Appeal Decision

Appeal Ref: APP/T2350/D/14/2219598

5 The Crescent, Dunsop Bridge, Lancs BB7 3BA

- The appeal is made under section 78 of the Town and Country Planning Act 1990 against a refusal to grant planning permission.
 - The appeal is made by Mr Gil Hughes against the decision of Ribble Valley Borough Council.
 - The application Ref 3/2014/0124, dated 10 January 2014, was refused by notice dated 25 March 2014.
 - The development proposed is an extension to side of dwelling, conservatory to rear and 2 no. rooflights.
-

Project: Proposed Extension at 5 The Crescent, Dunsop Bridge. For Mr and Mrs Hughes.		Ron Valovin, Architectural Services, 9 Green Drive, Clitheroe, Lancs. BB7 2BB. Tel. 01200 427167.	
Title: PROPOSED PLANS AND ELEVATIONS.			
Scale: 1 to 50	Date: 10/12/13	Drawn: JAV	File Name: 390-2

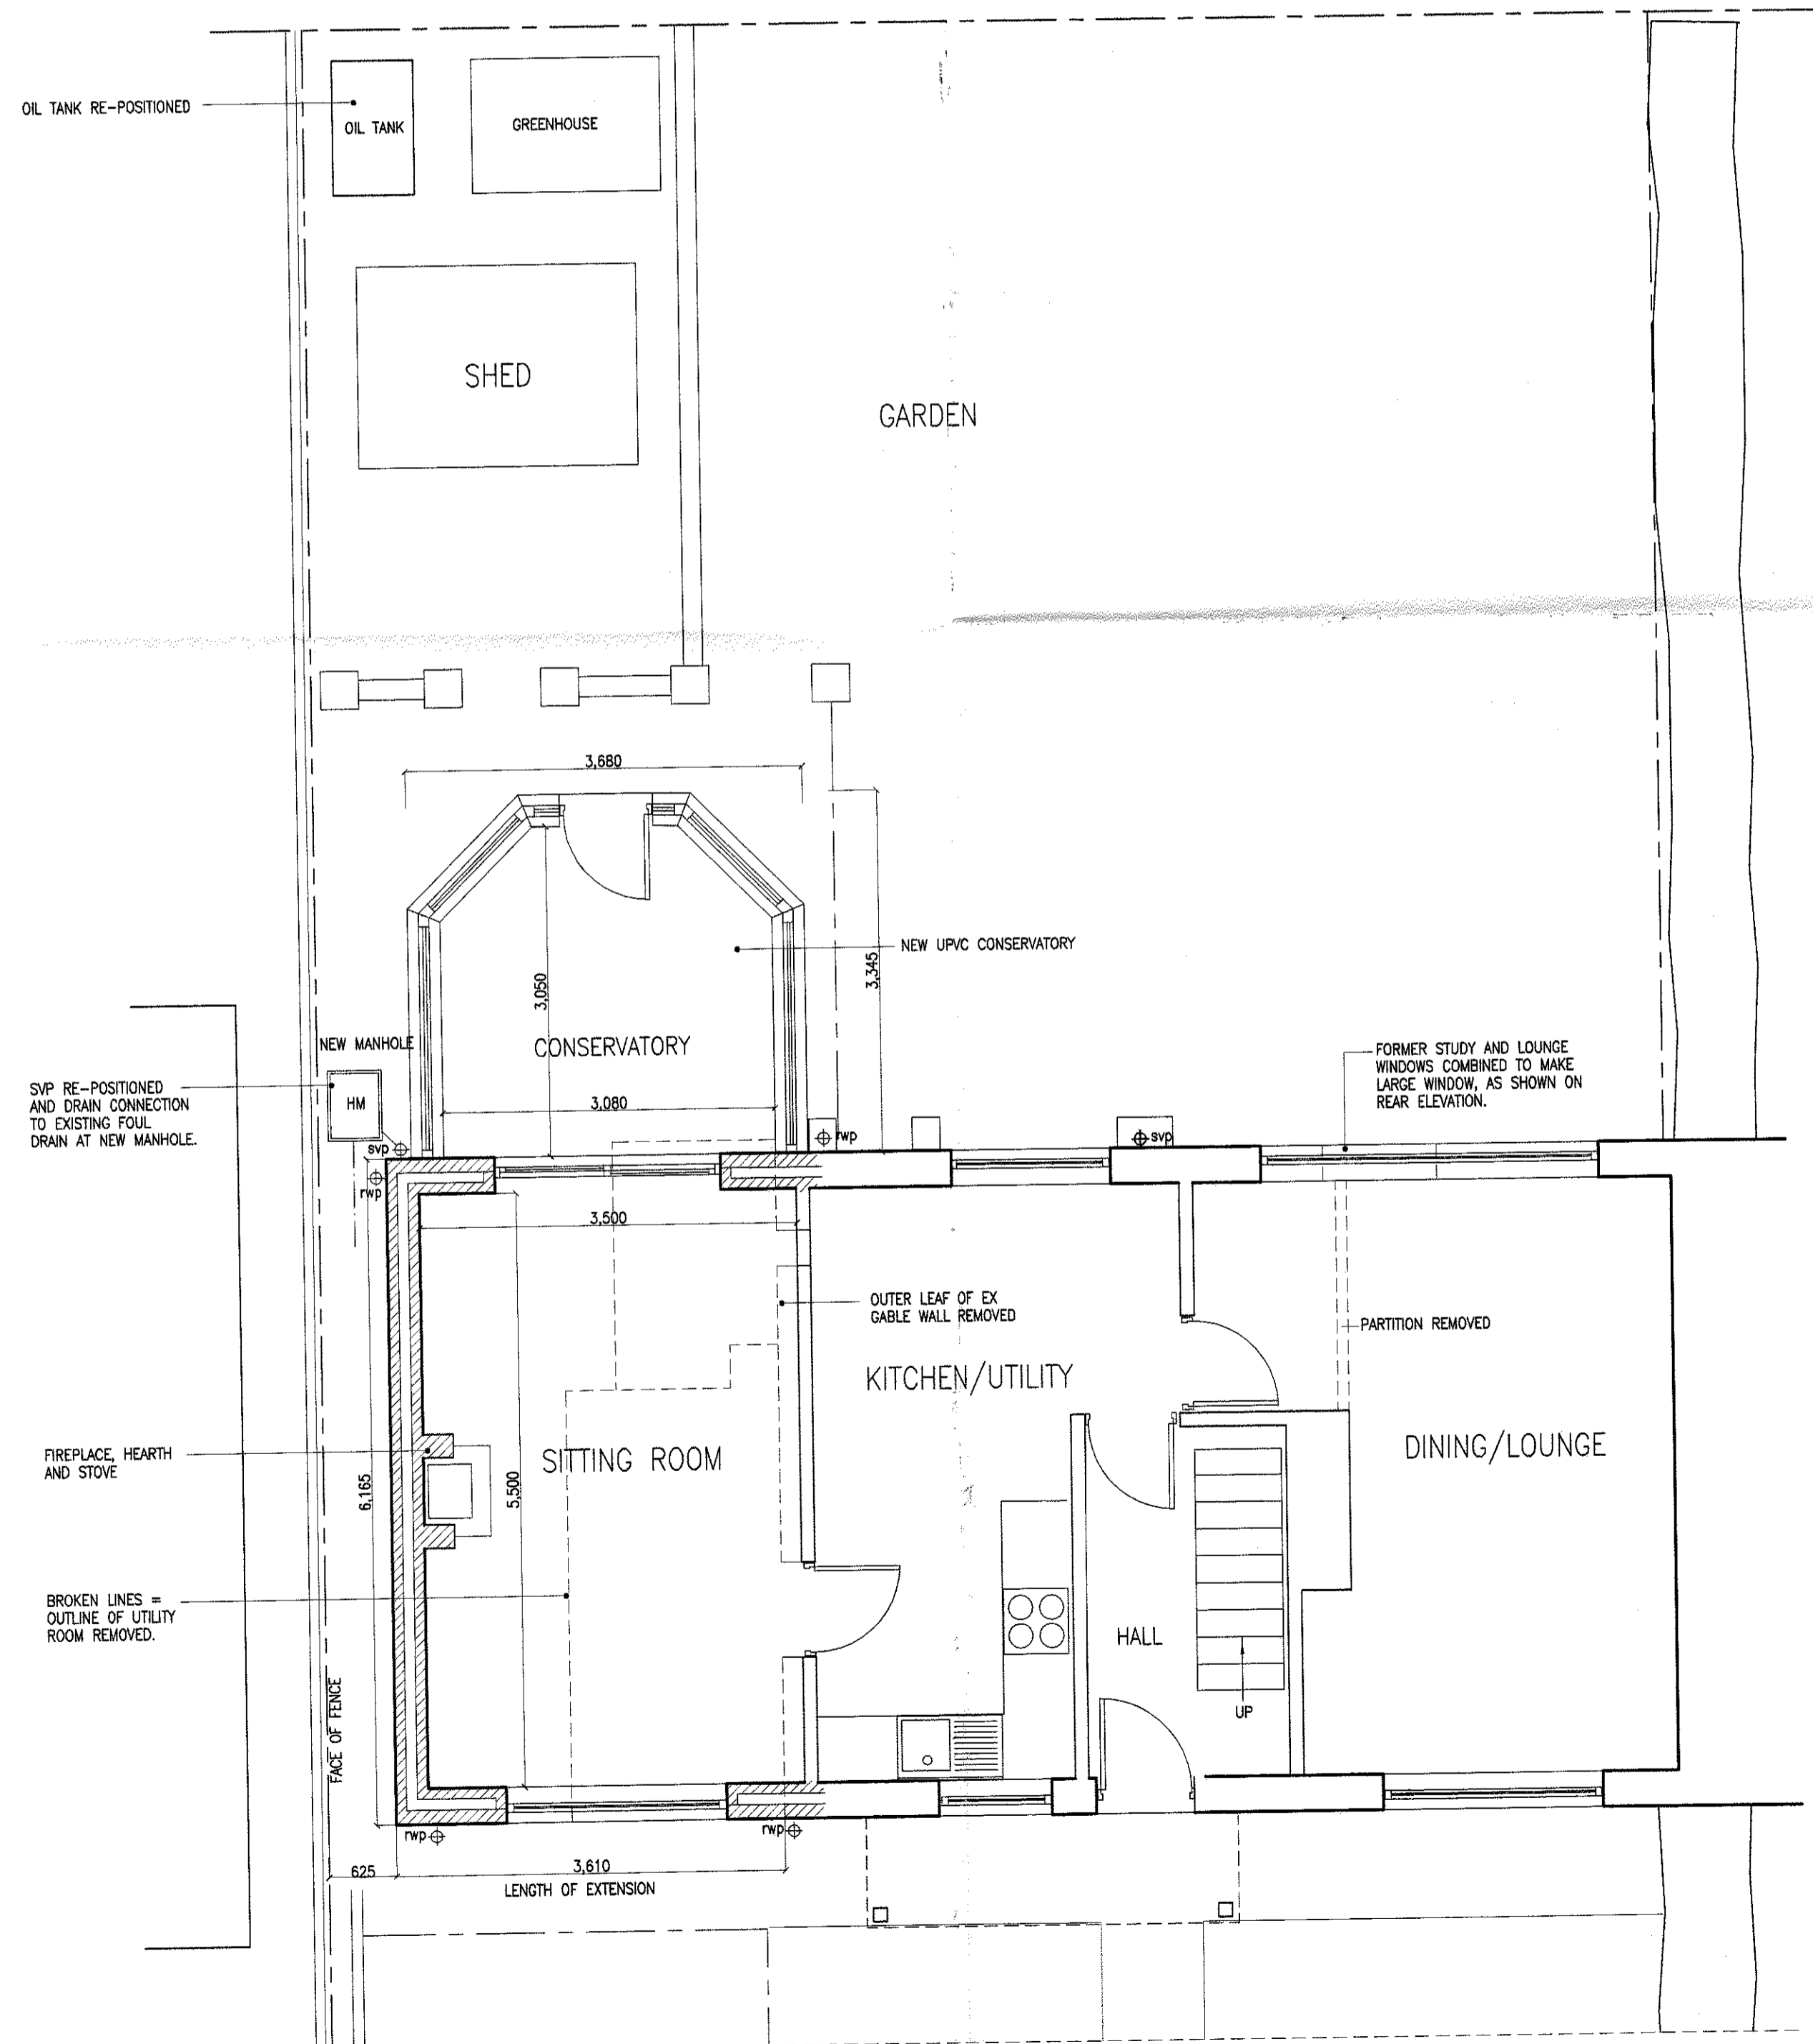
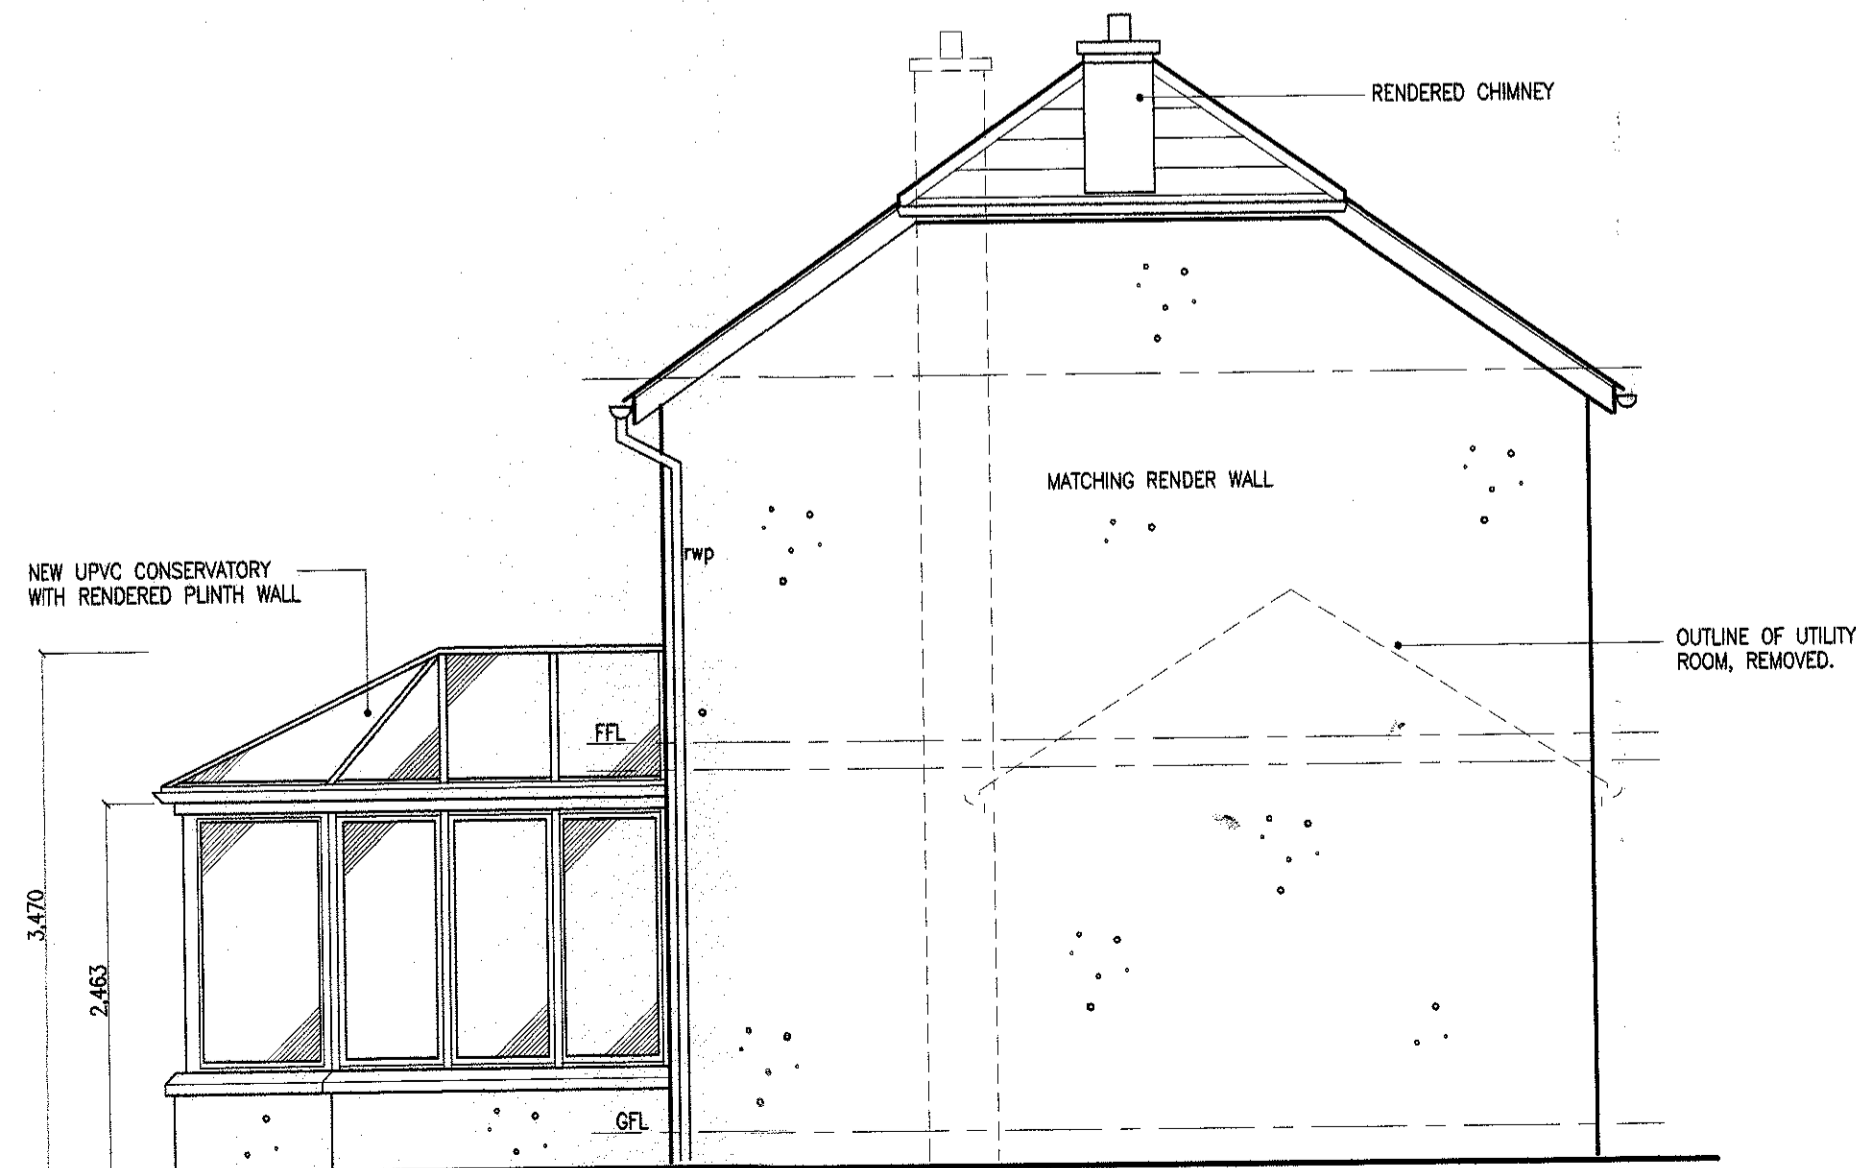
4. The appeal relates to a semi-detached property. It sits within a crescent containing three similar pairs of semi-detached houses along with a pair of timber clad semi-detached dormer bungalows. The pairs of dwellings are set spaciouly apart and this is a noticeable element which contributes positively to the overall character and appearance of The Crescent, which sits within an Area of Outstanding Natural Beauty (AONB).
 5. The proposal seeks to replace a modest single storey structure at the side of the appeal dwelling which accommodates a utility with a much larger two storey
-

extension spanning its full depth and sitting flush with the main front elevation. The adjacent dwelling, No. 4 The Crescent, has a similar two storey extension to its side. As a result, the gap between the two houses, particularly at first floor level, would be dramatically reduced if the proposed extension was built. Although the extension would be finished in appropriate external materials and detailing, the effect would harmfully degrade the overall spacious arrangement of the dwellings within The Crescent and detract from its setting within the AONB.

6. For these reasons, I conclude that the proposed two storey side extension would harm the spacious character and appearance of the street scene and its setting within the AONB. In such terms, it conflicts with saved policies G1, ENV1 and H10 of the adopted Ribble Valley District Wide Local Plan (LP) and policies DMG1, EN2 and DMH5 of the Council's emerging Core Strategy (CS) which are broadly consistent in this regard, along with the aims of the Council's adopted Supplementary Planning Guidance titled '*Extensions and Alterations to Dwellings*' (SPG).

7. The proposal includes a conservatory which would sit directly at the back of the two storey extension, projecting into the rear garden of the appeal property. The submitted plans show that it would have clear glazed sides above a dwarf wall and the Council considers that this would result in undue overlooking of the neighbouring gardens. The existing large shed of No. 4 The Crescent which sits along the common boundary would obscure views into the rear garden of this property whilst a tall hedge along the boundary with No. 6 would minimise views into this garden. In any event, the fitting of obscured glazing to the side panels of the conservatory or additional boundary screening would prevent any overlooking into these gardens, and the appellant has indicated that a condition to either effect would be satisfactory.

2. The appeal is dismissed.

8. On this basis, I am satisfied that the conservatory need not lead to an unacceptable loss of privacy for neighbours and therefore need not conflict with saved policies G1 and H10 of the LP, policies DMG1 and DMH5 of the CS and the SPG in this respect.
